**DEVIATION REQUEST
AND DECISION FORM IN
ASSOCIATION WITH A
REQUEST FOR A PUD
MODIFICATION FROM
THE ECM**

Project Name : Urban Landing Preliminary Plan

A deviation from the standards of or in Section **LDC 8.4.4 (E) (2)** and Section 2.2.4.B.7 Fig. 2-17, Table 2-7 and Section 2.3.8 of the Engineering Criteria Manual (ECM) is requested.

DESIGNED BY	MAW	SCALE	DATE	4/01/2024
DRAWN BY	MAW	(H) 1" = 40'	SHEET	3 OF 9
CHECKED BY	(V) 1" = N/A	JOB NO.	1308.01

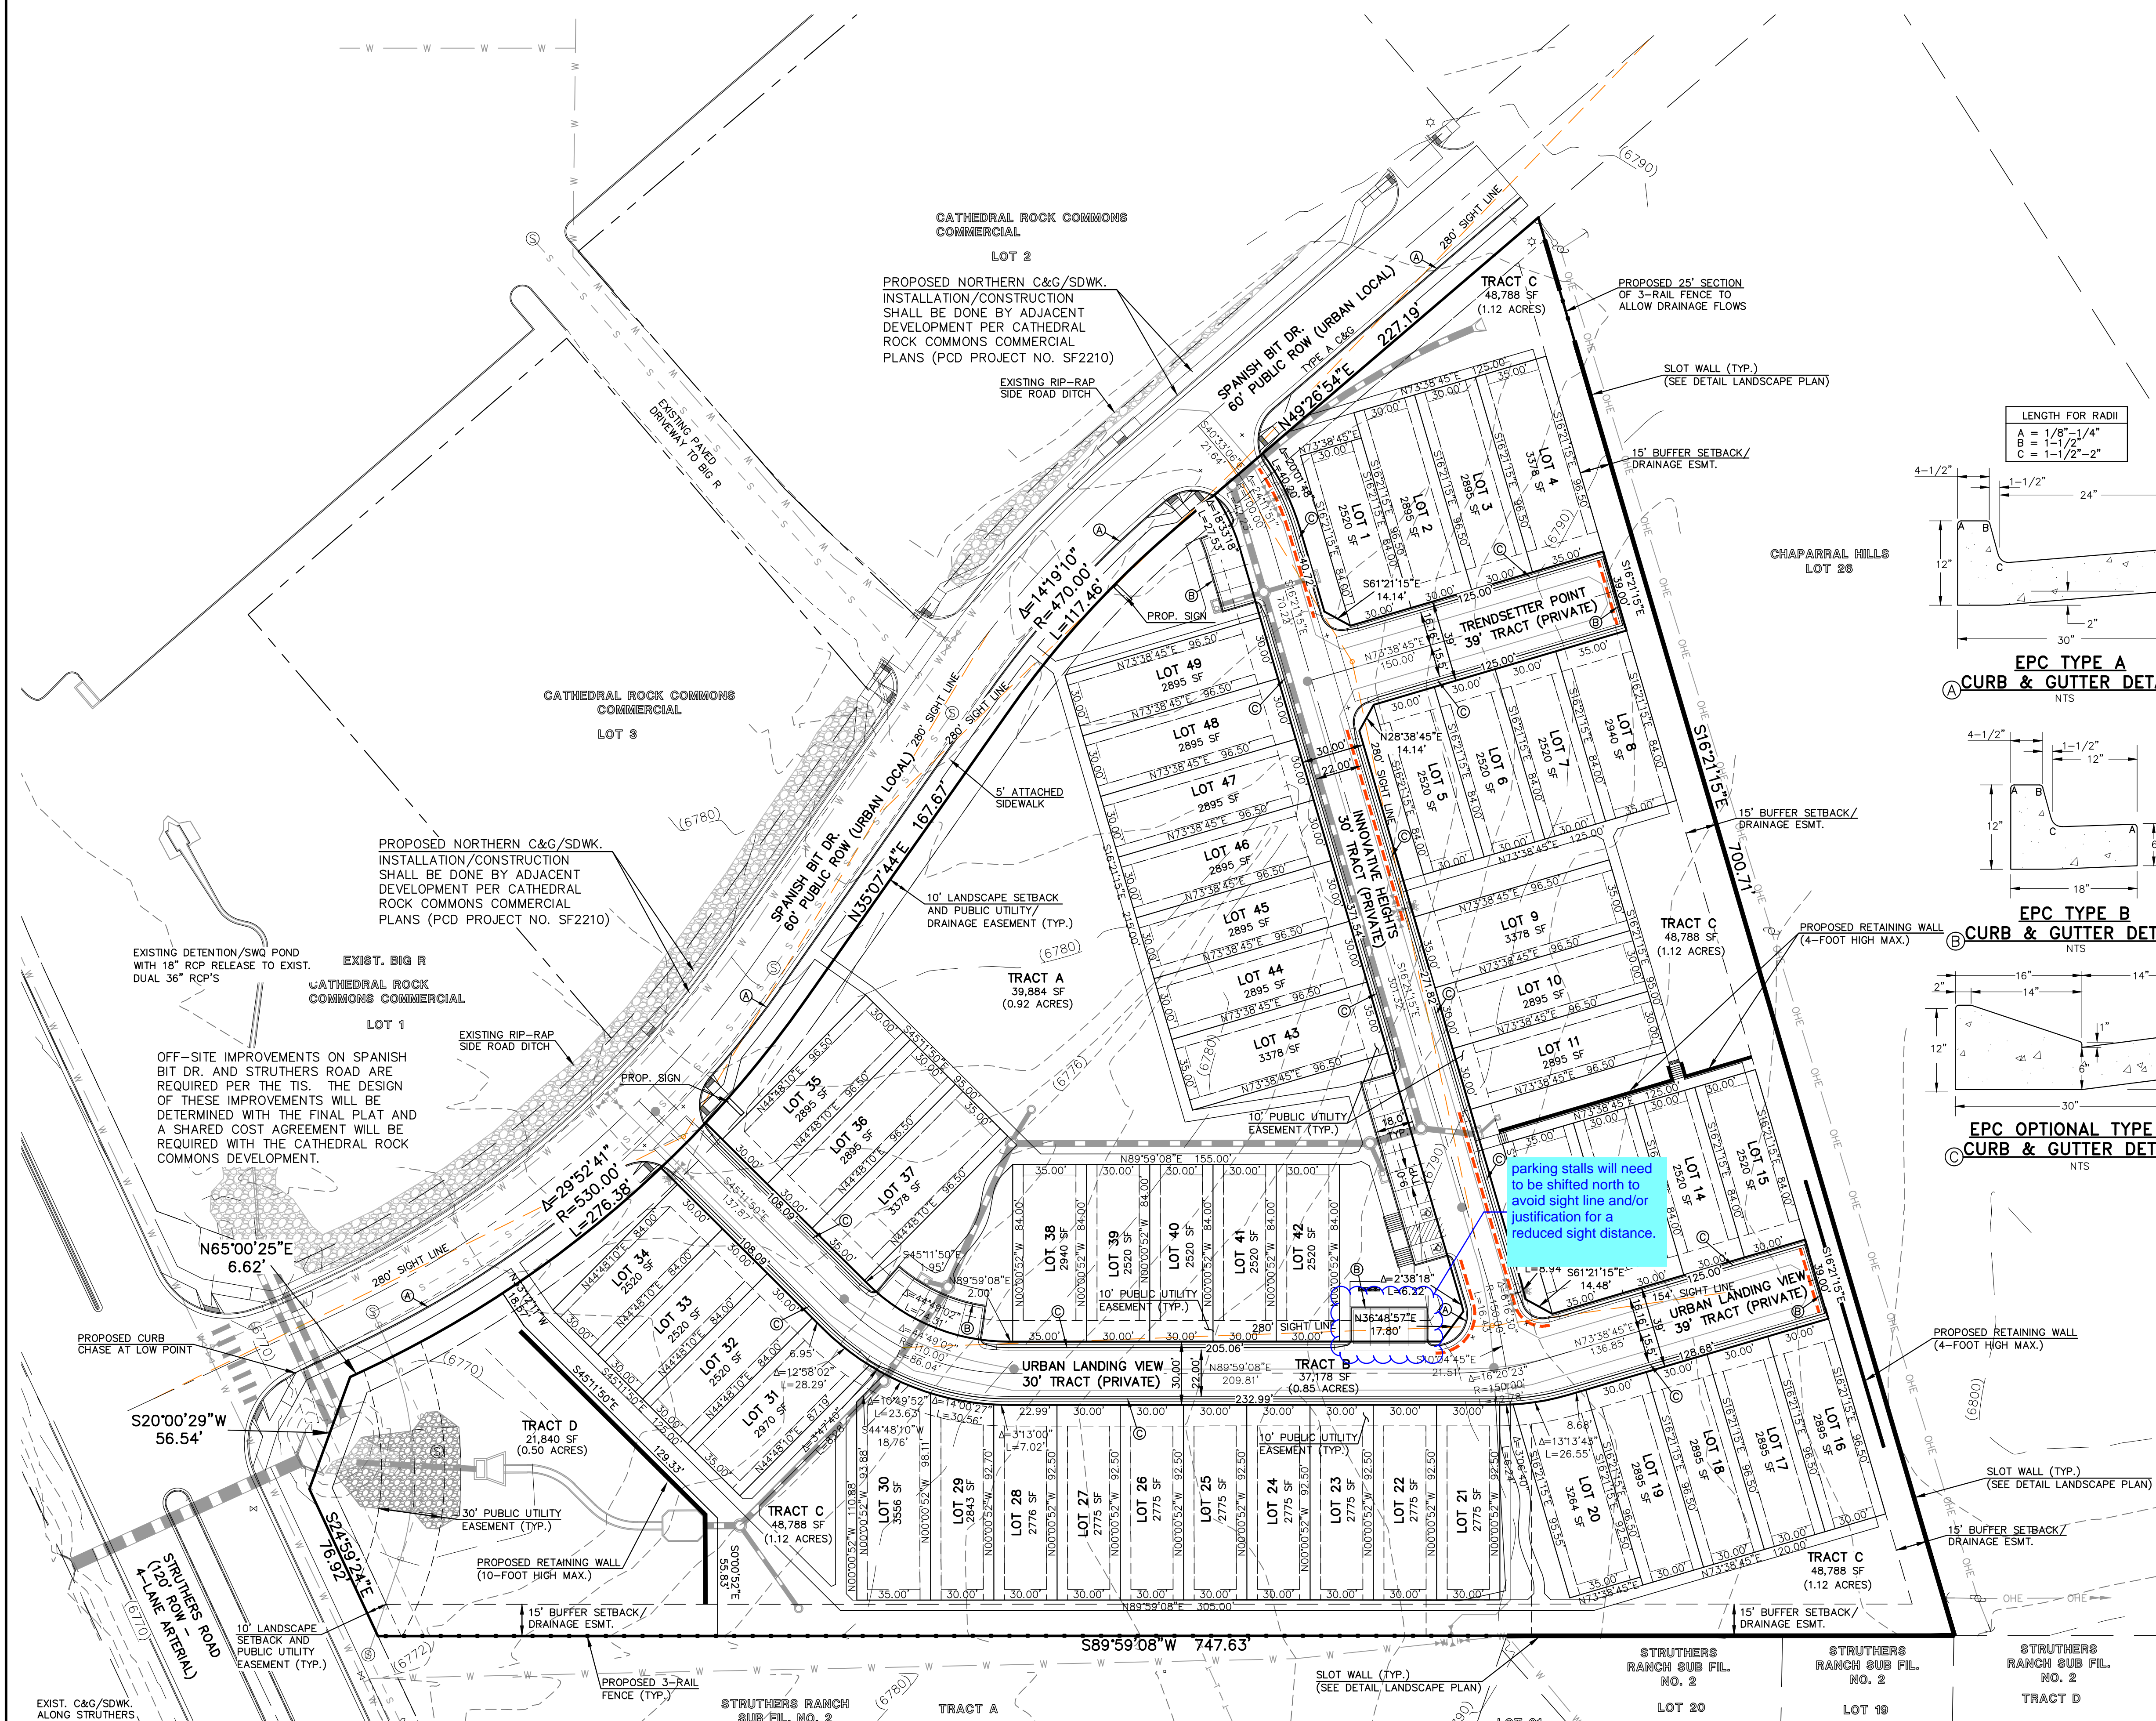
Use of private roads is a deviation from the following:
Typical Roadway cross section for Urban Local Low-volume

Use of private roads with no cul-de-sac is a deviation from the following:
Roadway terminations require a cul-de-sac turn-around

Intersection Spacing less than 150' is a deviation from the following:
Local Low Volume intersection spacing min. is 150'

The unique small lot urban residential community being proposed will be rear loaded from private roads similar to alleys. While the main community access is from a standard public local roadway (Spanish Bit Dr.), the use of the private roadways is limited to closed looped areas that will be signed as being private.

Based on the smaller lot and unit sizing and the configuration of this specific property, the request is for an internal private street intersection to be 134' from Spanish Bit Dr. rather than the County std. of 150' for urban local public roadways. Given this proposed access is considered a "low volume" road only serving 8 units, this 16' difference has no significant impact of the intersection movements.

This request has been determined to have met the criteria for approval. A deviation from Section LDC 8.4.4 (E) (2) and Section 2.2.4.B.7 Fig. 2-17, Table 2-7 and Section 2.3.8 of the ECM is hereby granted based on the justification provided.
